From: Sarah Burrow <Sarah.Burrow@arun.gov.uk>
Sent: 06 May 2021 10:29
To: Planning.Responses <Planning.Responses@arun.gov.uk>
Cc: Simon Davis <Simon.Davis@arun.gov.uk>; Paul Cann <Paul.Cann@arun.gov.uk>
Subject: RE: Planning Consultation on: FP/80/21/DOC

Engineers Comments Regarding Surface Water Drainage

Application No: FP/80/21/DOC

Site Address: MOW COTTAGE WORMS LANE FELPHAM

| Drawing Number                                                                                                                           | 2106/SK3 |             | Revision<br>- |

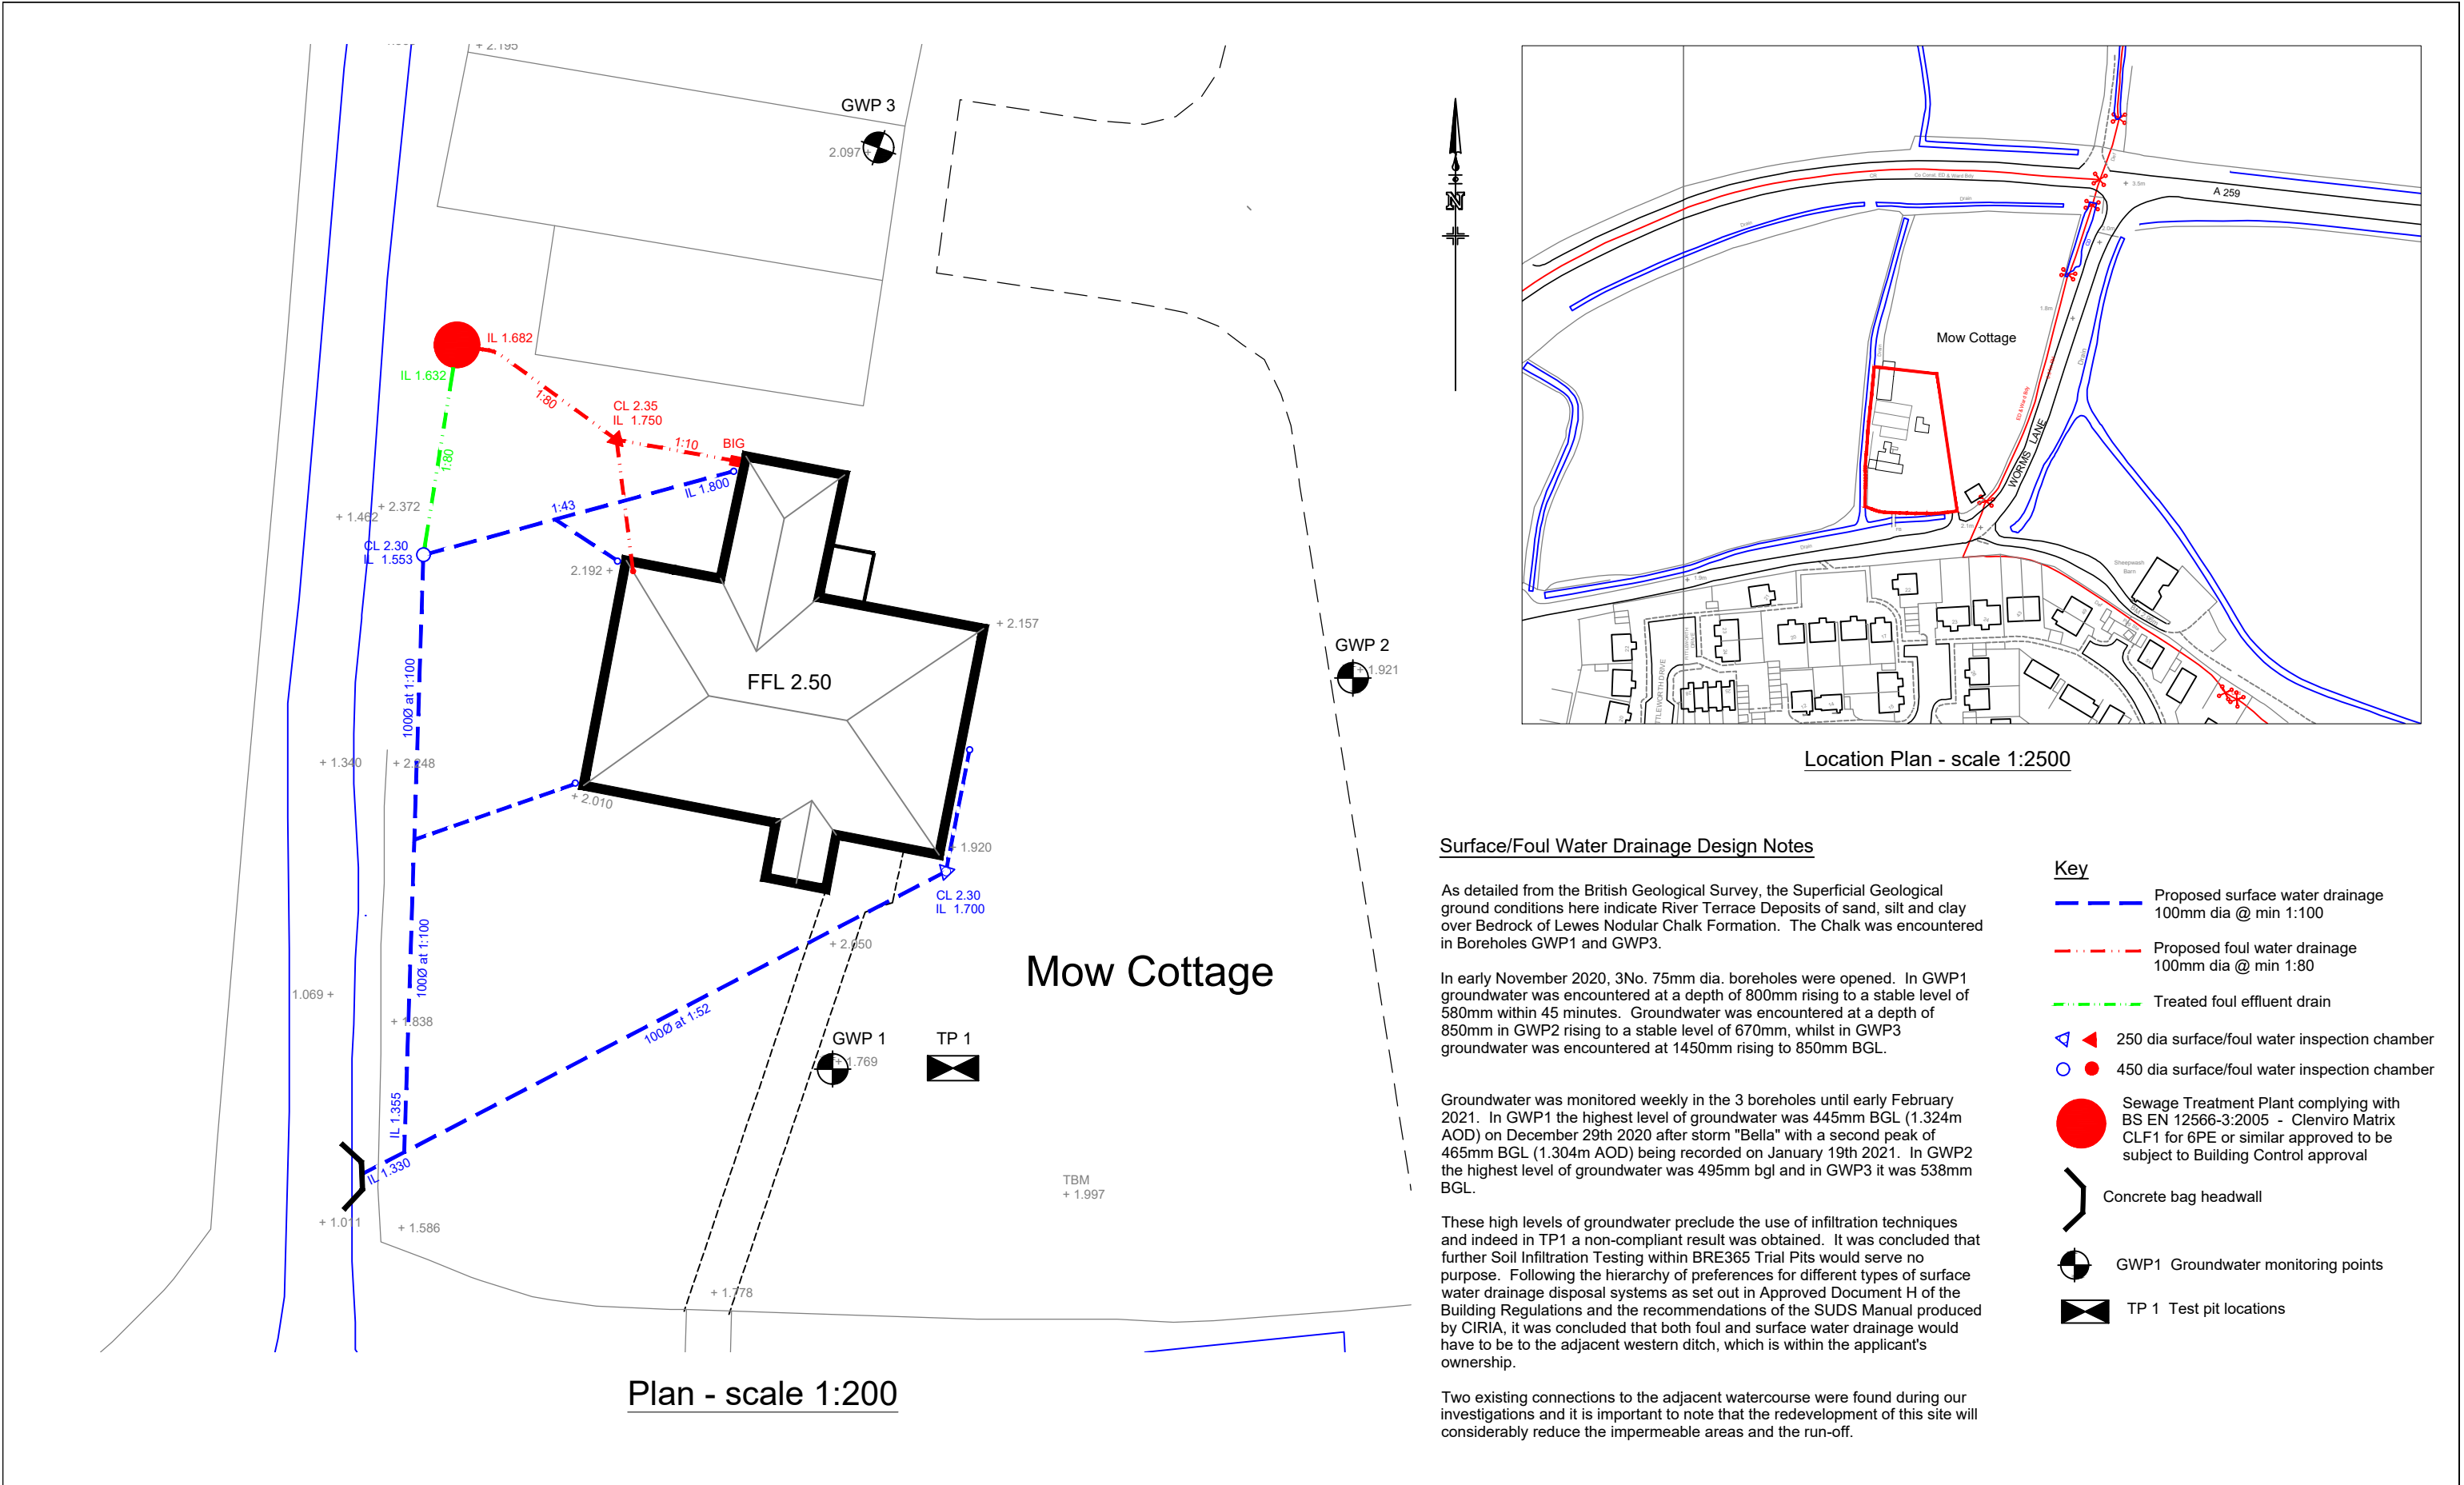
At present there is no effort made to restrict or slow the discharge rate of surface water to the ditch. It is difficult to discern an appropriate discharge rate due to the history of the site. Technically it is fair to consider the site a brownfield site as a house was formerly located there (before the fire in 2006) and it is assumed that there is existing hard standing on site as the design notes state that "redevelopment of this site will considerably reduce the impermeable areas and run off". However, we have no evidence to substantiate this claim, no historic floor plans, no photos, no previous impermeable area plan and no proposed impermeable area plan. If we consider the site as brownfield then policy indicates that we should expect 50% betterment on the existing discharge rates.

In addition, even if no storage is required to attenuate flows before a restricted discharge (ie tanks or ponds/basins prior to an orifice or Hydrobrake) then we would still like to see effort made to slow the rate of discharge in other ways. It is suggested that the use of water butts with diverter kits could achieve this to an extent. It is unclear whether a driveway is being introduced for the development, but if so, diverting surface water through lined permeable paving would have the dual benefit of slowing flows and providing water treatment.

1. A sumped manhole provided upstream of the headwall where the pipes connect.
2. If inspection chambers aren't provided on all pipe connections then please include a construction detail drawing for these junctions.
3. A note regarding pipe materials and cover types on inspection chambers/manholes on layout.
4. Please include hard bed, soft bed and top of bank levels on the headwall construction detail drawings.

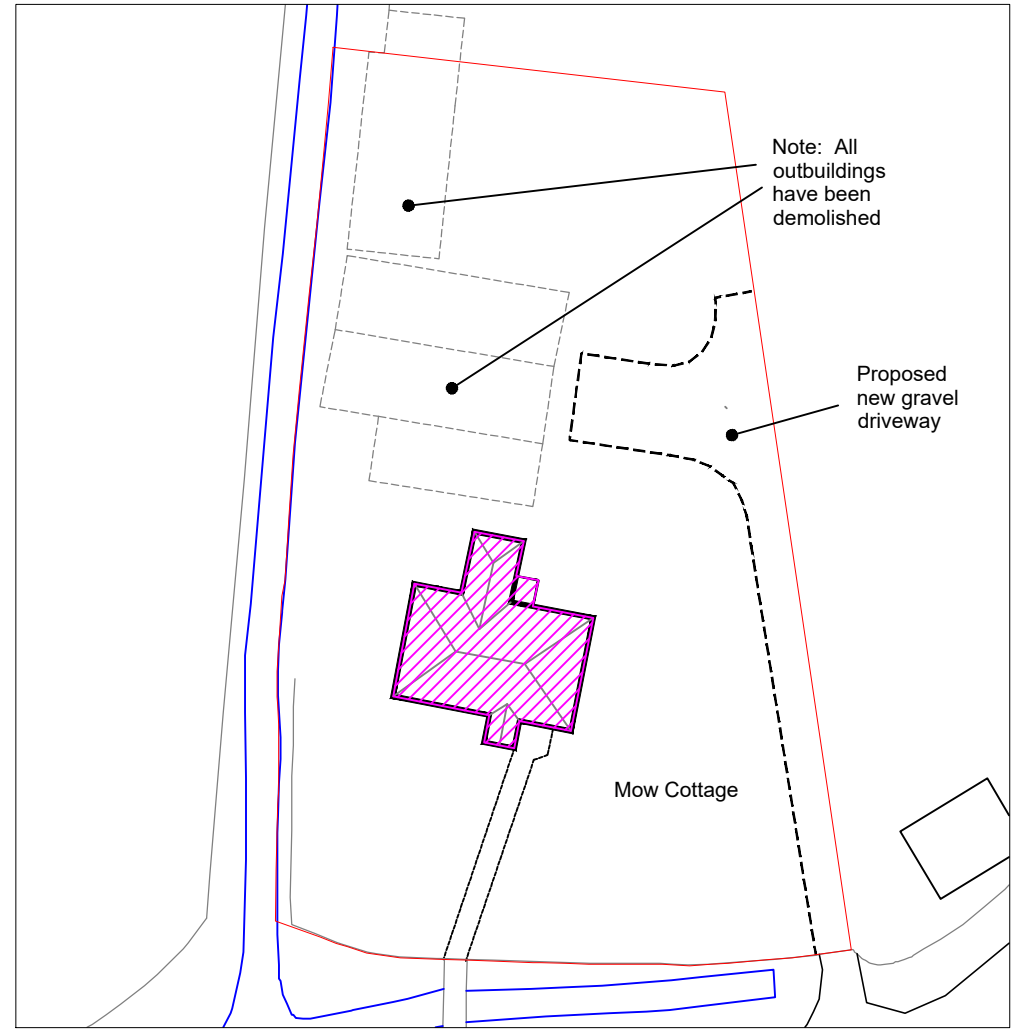
In order to better understand the existing system I would expect the pre-development runoff rate calculations to be provided, even if these are to show that the new design will require no restriction of flow due to the reduction in impermeable area.
